**re: Geotechnical Response to City Comments  
Proposed Industrial Redevelopment  
135 Cardevco Road – Carp - Ontario**

**date: June 6, 2023**

**file: PG6018-MEMO.01 Revision 1**

FIGURE 5 – UNDERPINNING PROGRAM SECTION A-A

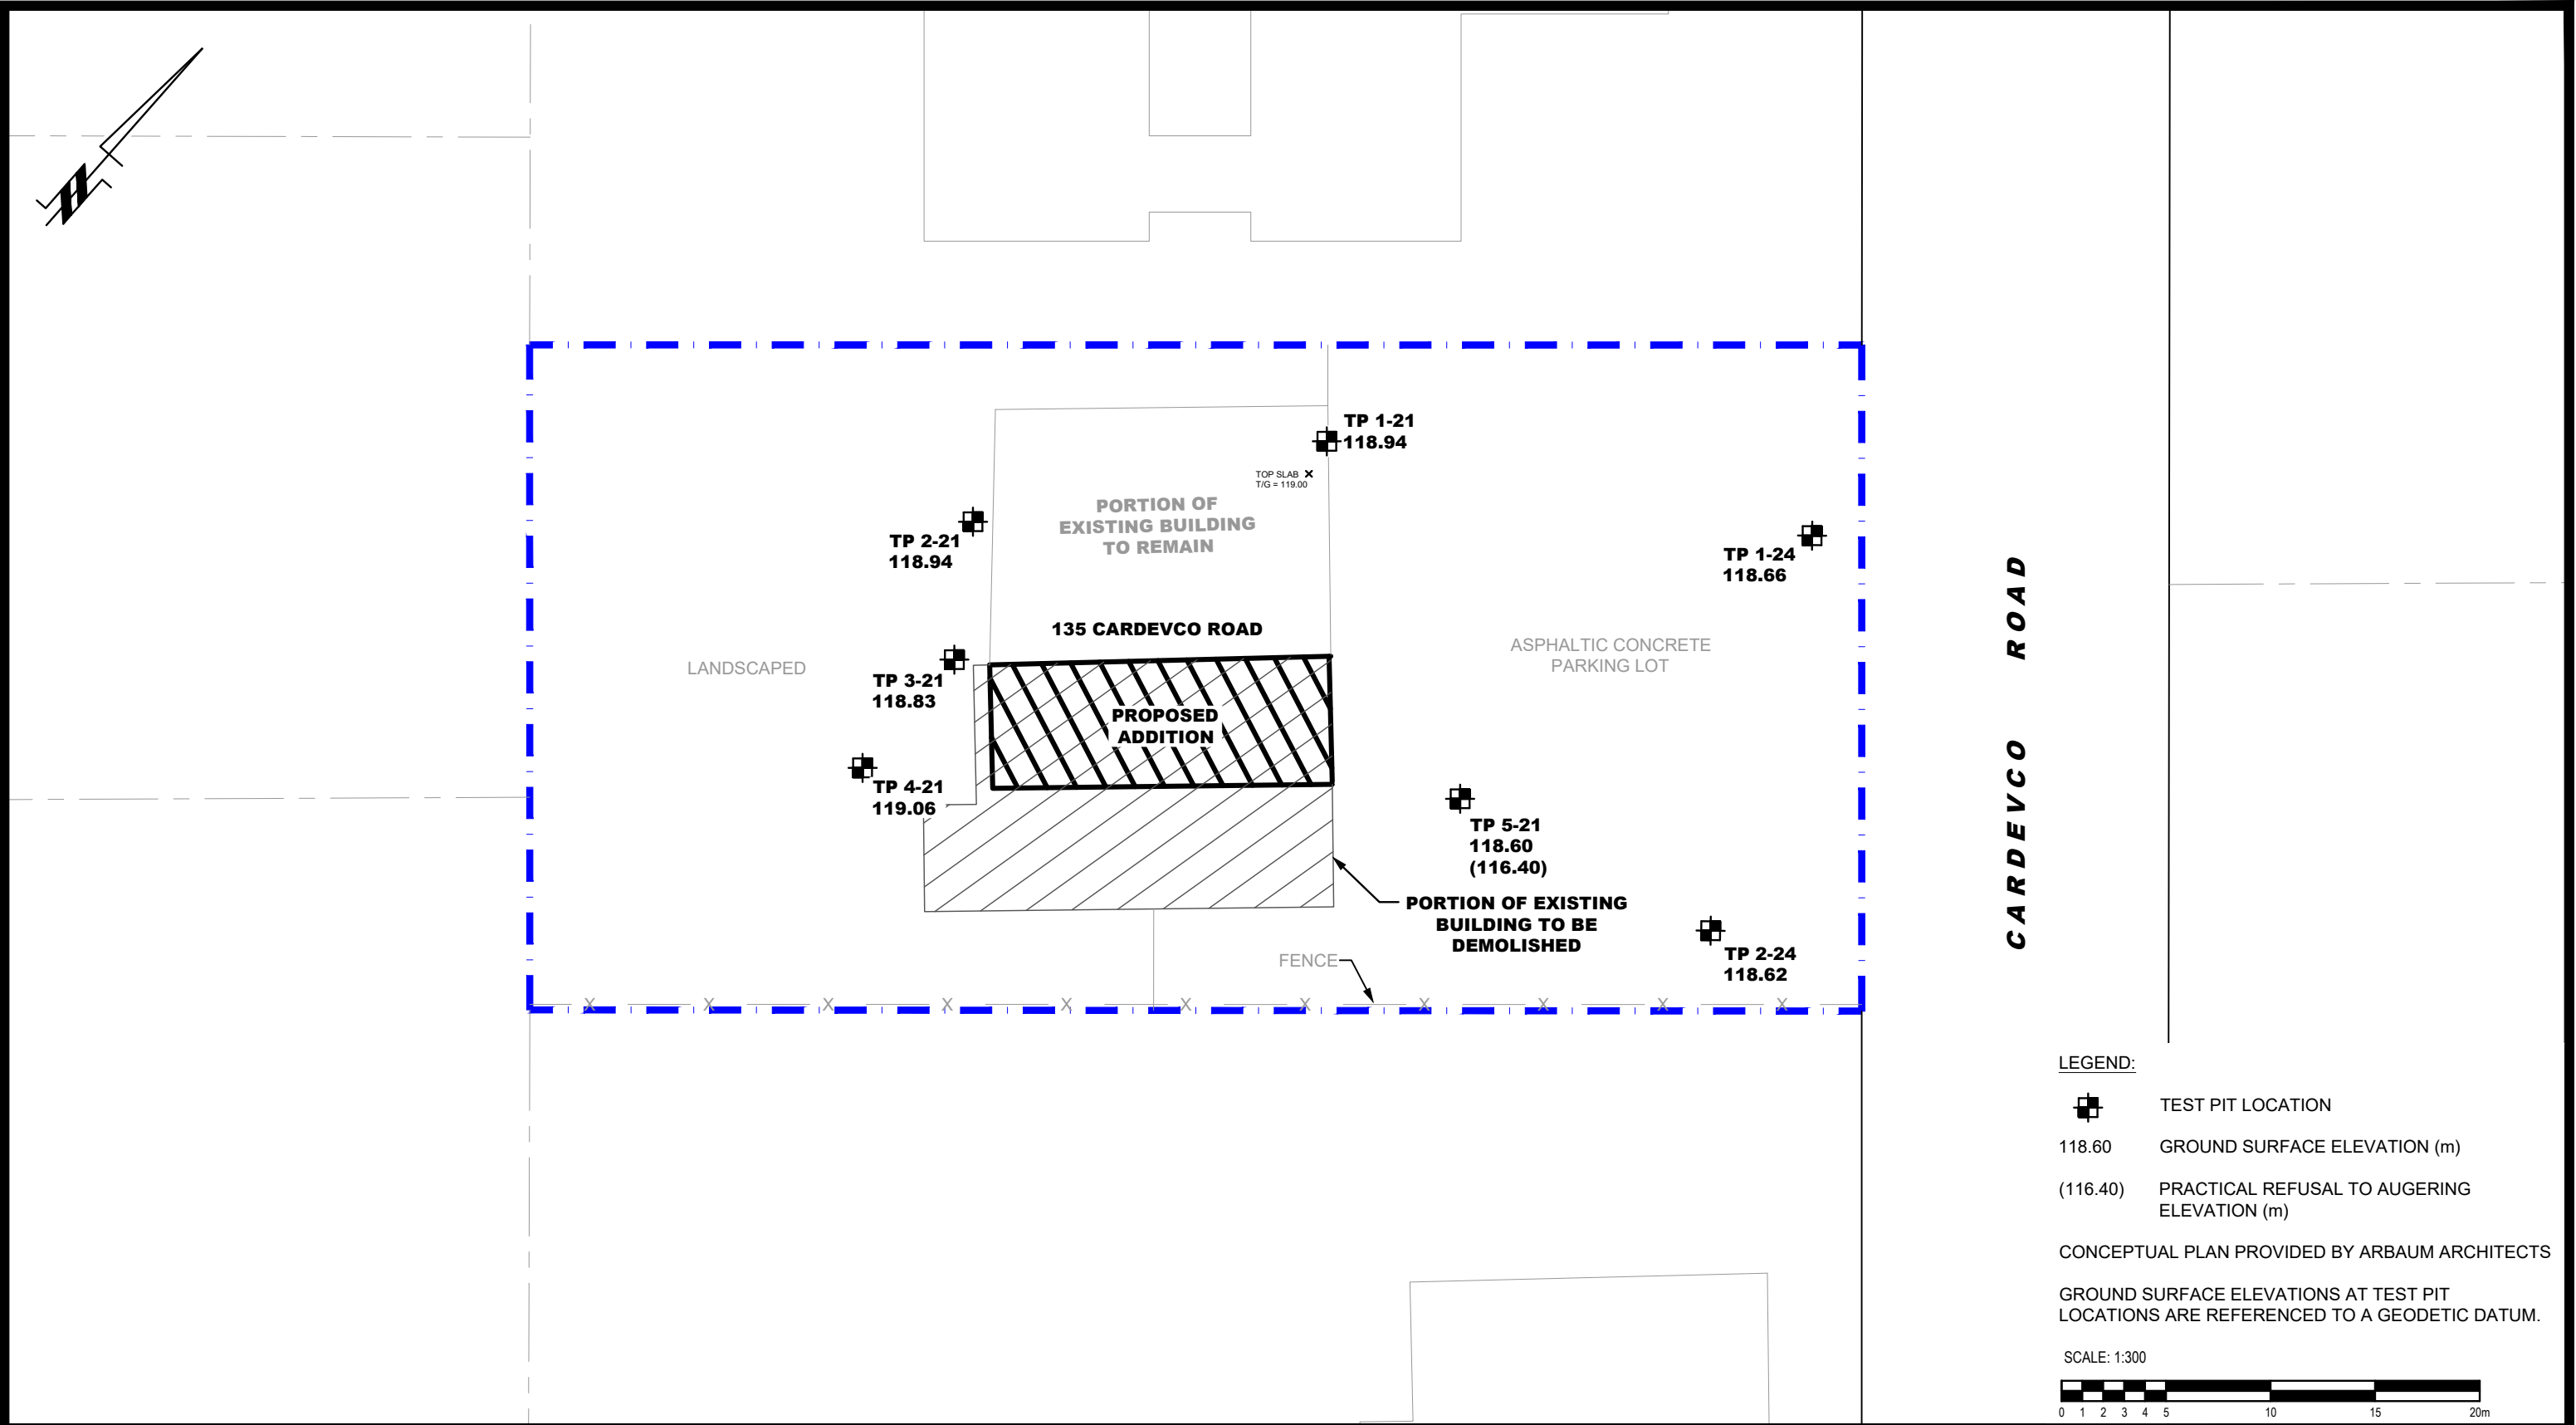
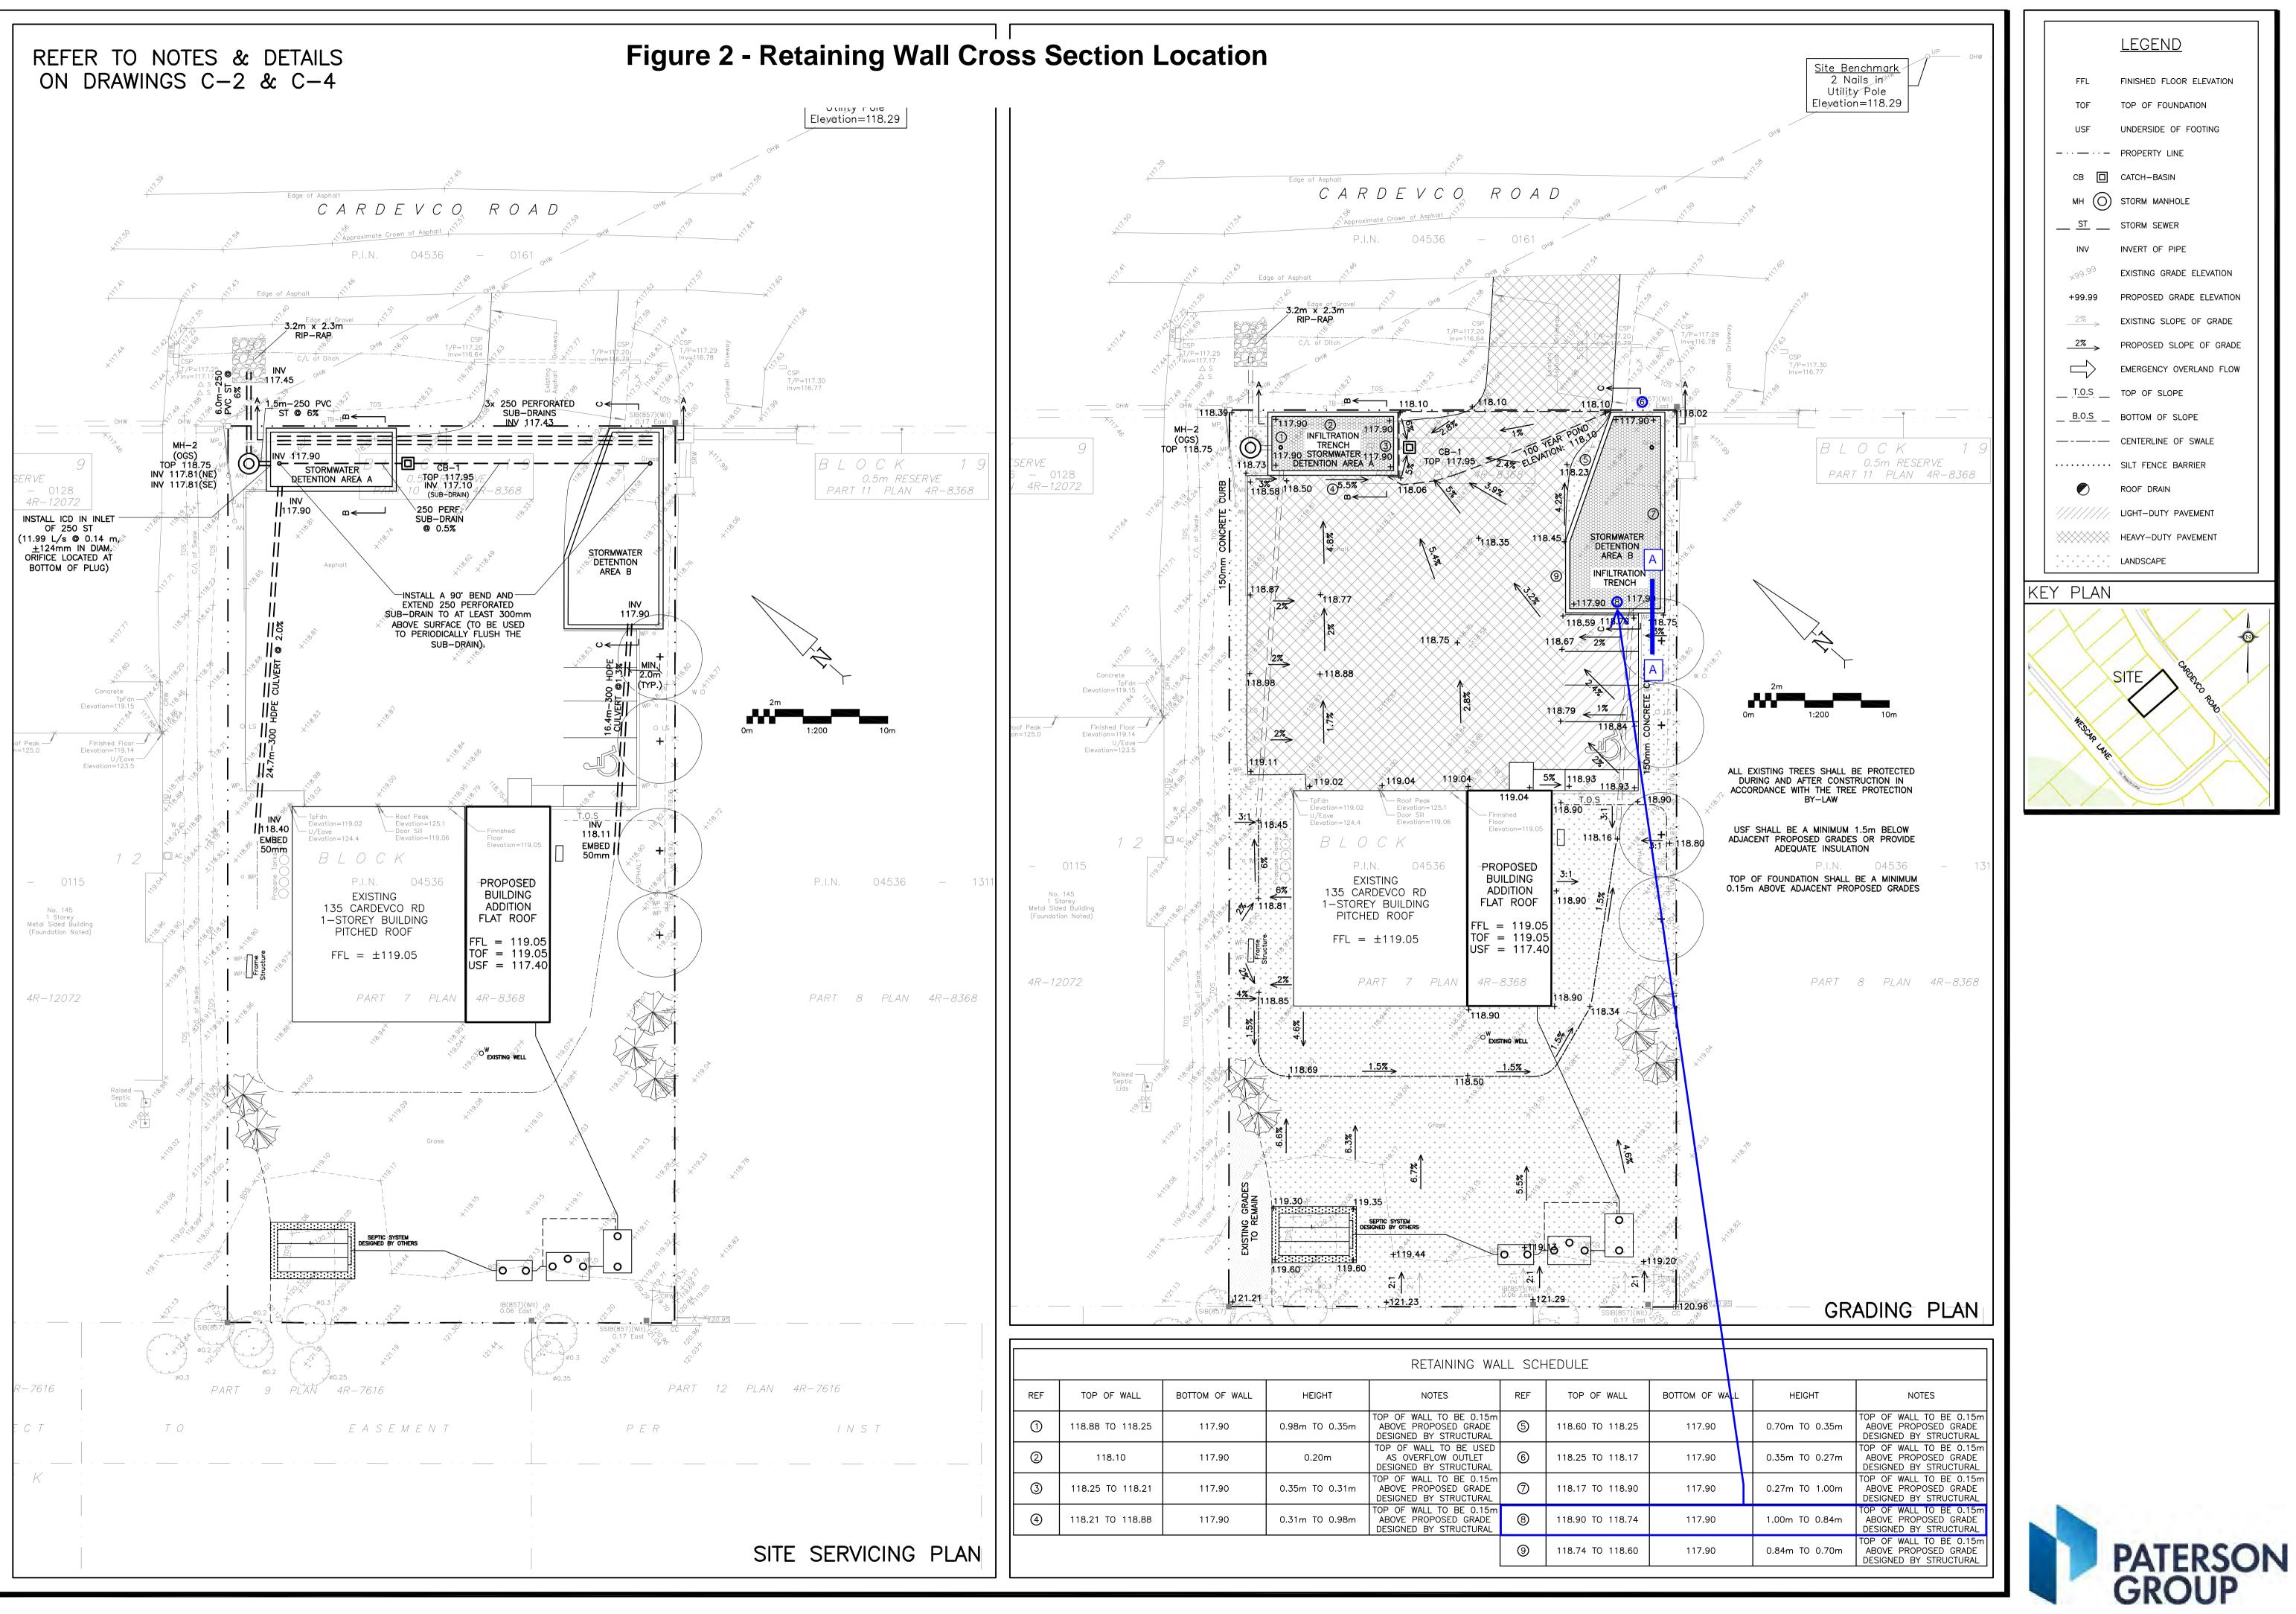
*No specific information is provided regarding protection of the structural integrity of the existing building due to potential ground movement and vibration, as it pertains to the excavation directly adjacent to its foundation for the proposed building foundation.*

*The likely depth of the required excavation directly adjacent to the existing building needs to be estimated.*

*Please evaluate if temporary slope instability is invoked, as a result of the above-mentioned construction activity.*

Based on the encountered soils and the anticipated depth of excavation, bedrock removal is not anticipated for the subject site. Therefore, vibration monitoring is not a concern from a geotechnical perspective.

Where excavation below existing footings is anticipated, reference should be made to Section 5.3 Foundation Design, for a discussion regarding the lateral support zone of existing footings. The required lateral support zone of 1.5H:1V for all footings should be protected. Where the lateral support zone of 1.5H:1V for the existing footings can not be provided, then underpinning of the existing footing can be done.
